Reference No: 2021/62/93700/W

Site Address: 92-94, Halifax Old Road, Birkby, Huddersfield, HD2 2RP

Description: Erection of single and two storey rear and single storey side extensions with external alterations, erection of canopy over outdoor gym and play area [within a Conservation Area]

Officer Report.

DWG No.	2132/02A
---------	----------

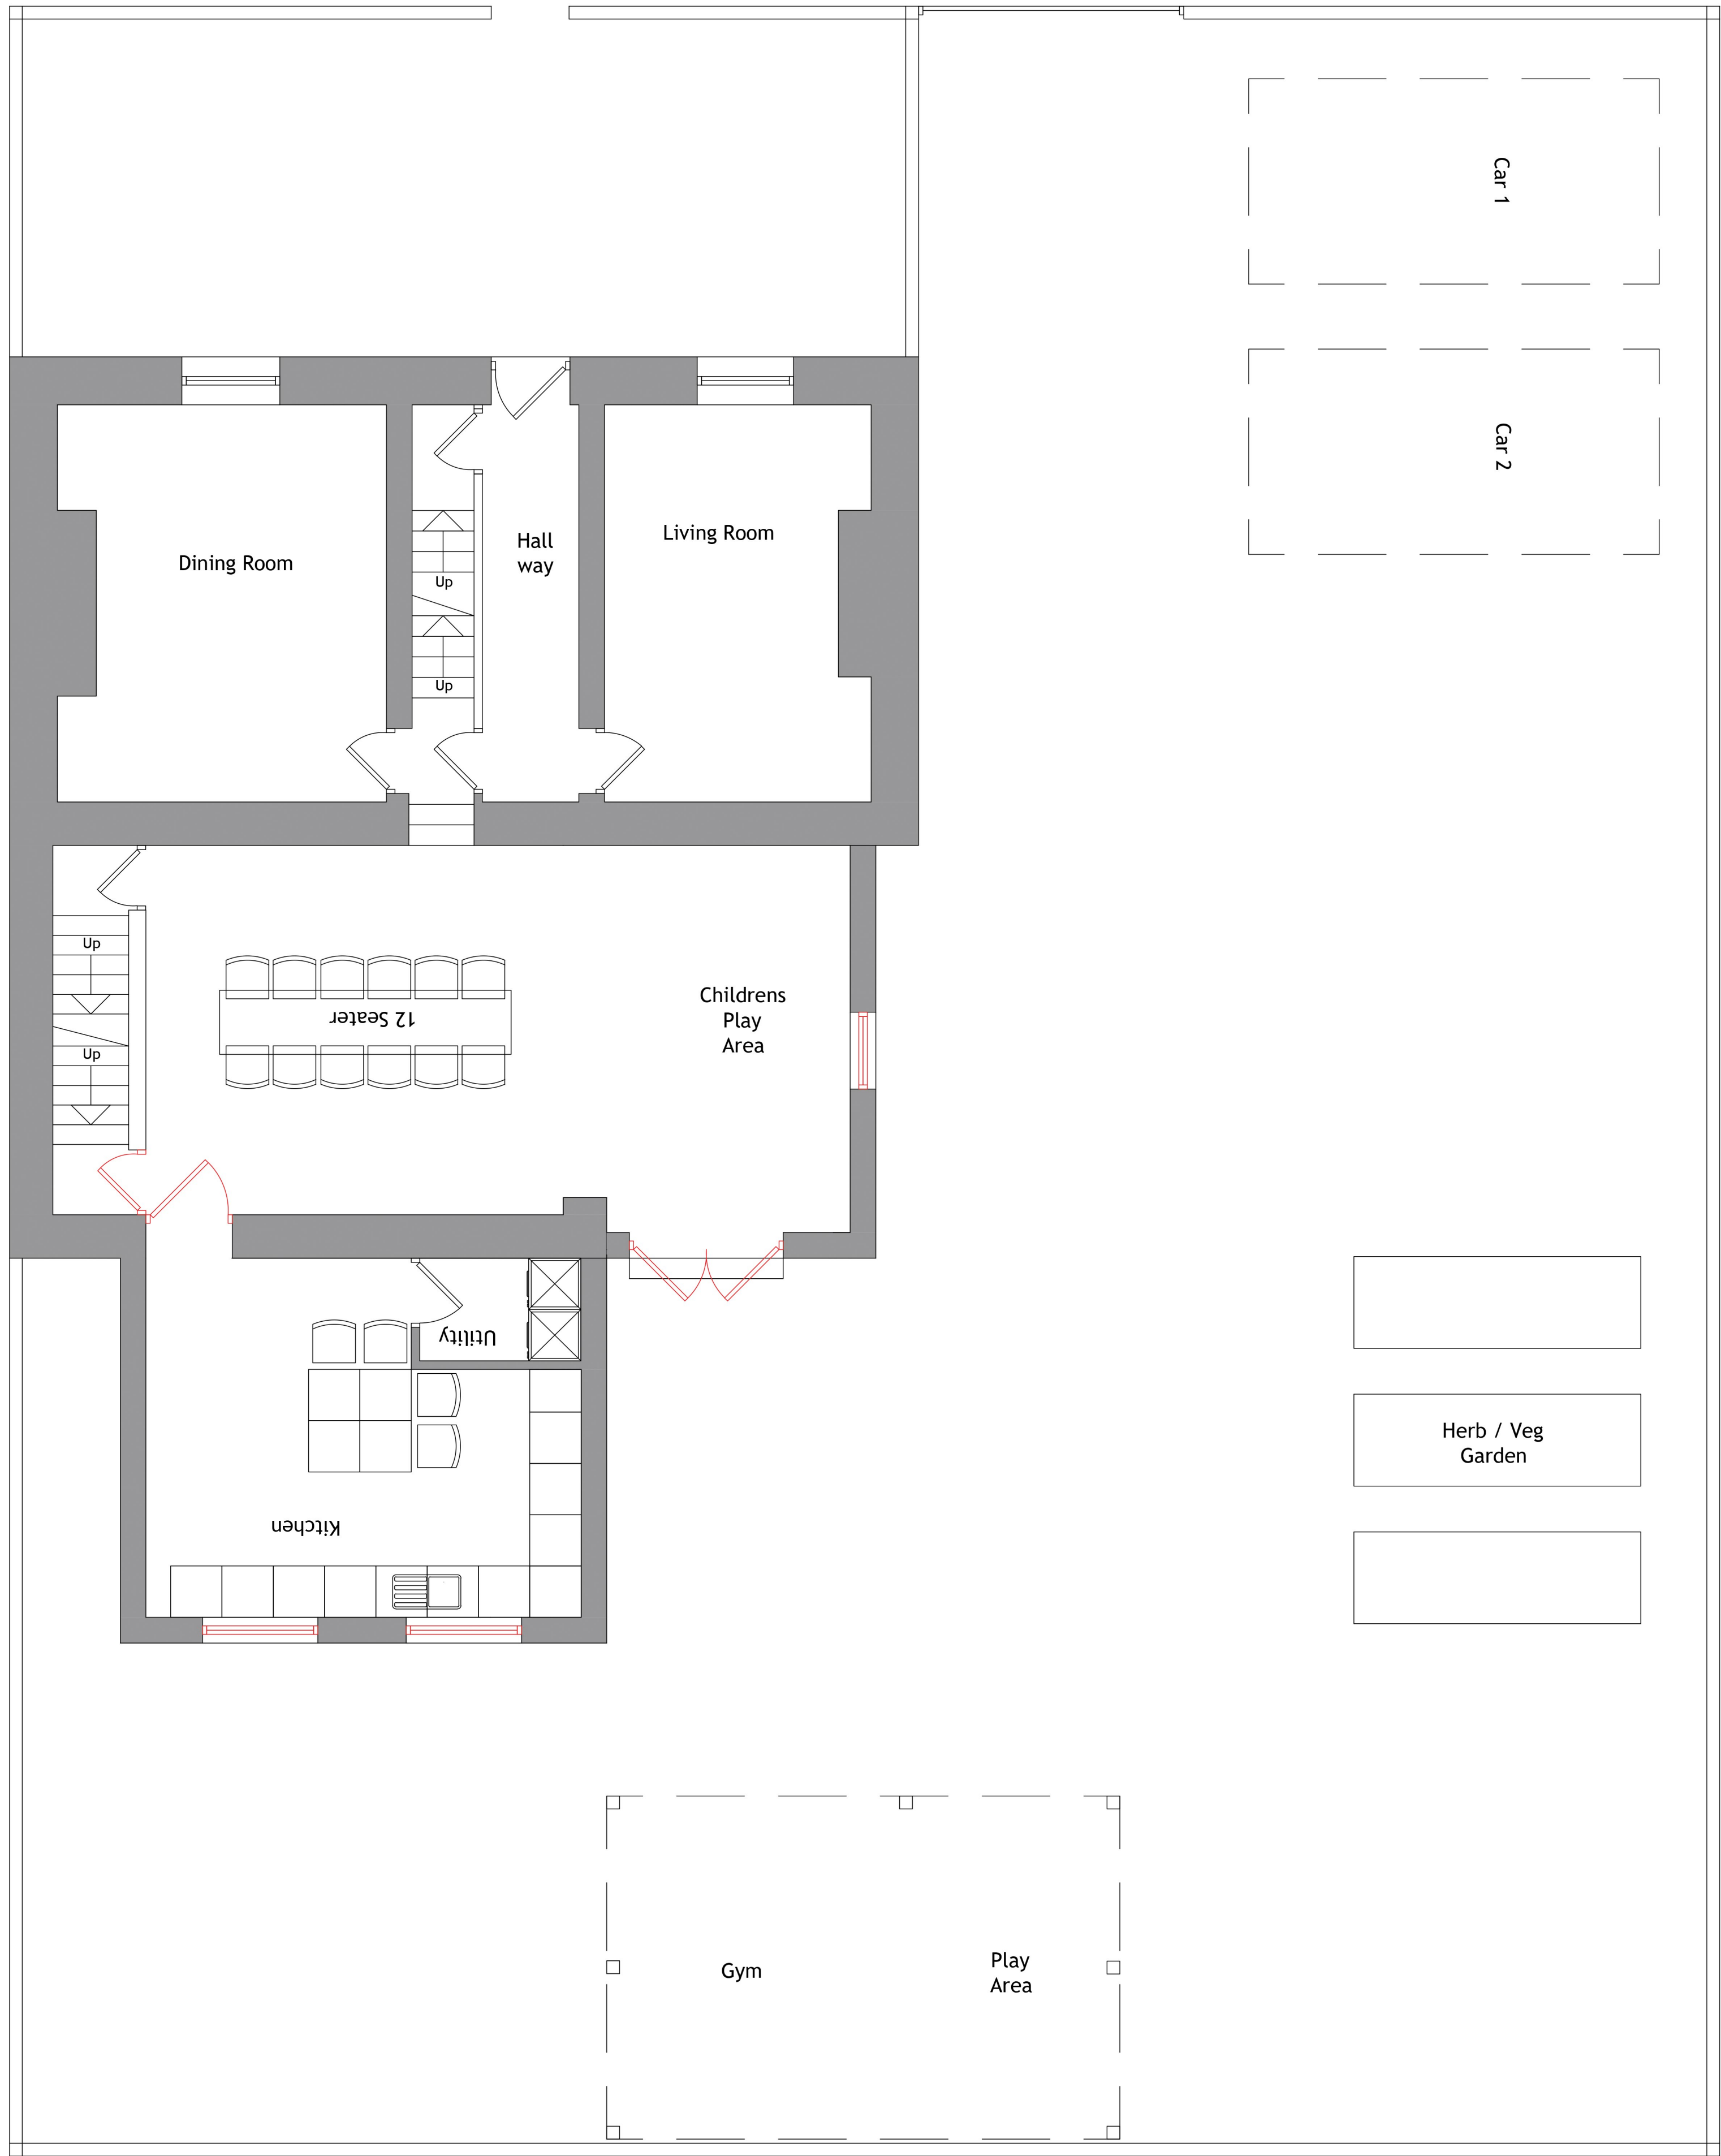
The case officer sought amended plans to reduce the width of the proposed rear extensions, so that a gap be retained between the extensions and southern joint boundary with No. 90 Halifax Old Road. This was so the extension would comply with the requirements of the Council's House Extensions and Alterations SPD, as well as for reasons of residential amenity.

Given that the two-storey rear extension has a projection of 3 metres and is to be set away from the shared boundary by 1.3 metres, it is not considered to pose significant harm to residential amenity with regard to being overbearing or overshadowing.

The applicant/agent submitted amended plans, setting the rear extensions in from the southern shared boundary by 1.3 metres. This adjustment meant that the extensions appropriately complied with the requirements of the SPD and that the scheme was much appropriate from a residential amenity perspective (discussed in greater detail in the 'Assessment' section of this report).

Response: this concern was addressed through negotiation whereby amended plans were submitted which set the proposed rear extensions in from the shared neighbouring boundary by 1.3m.
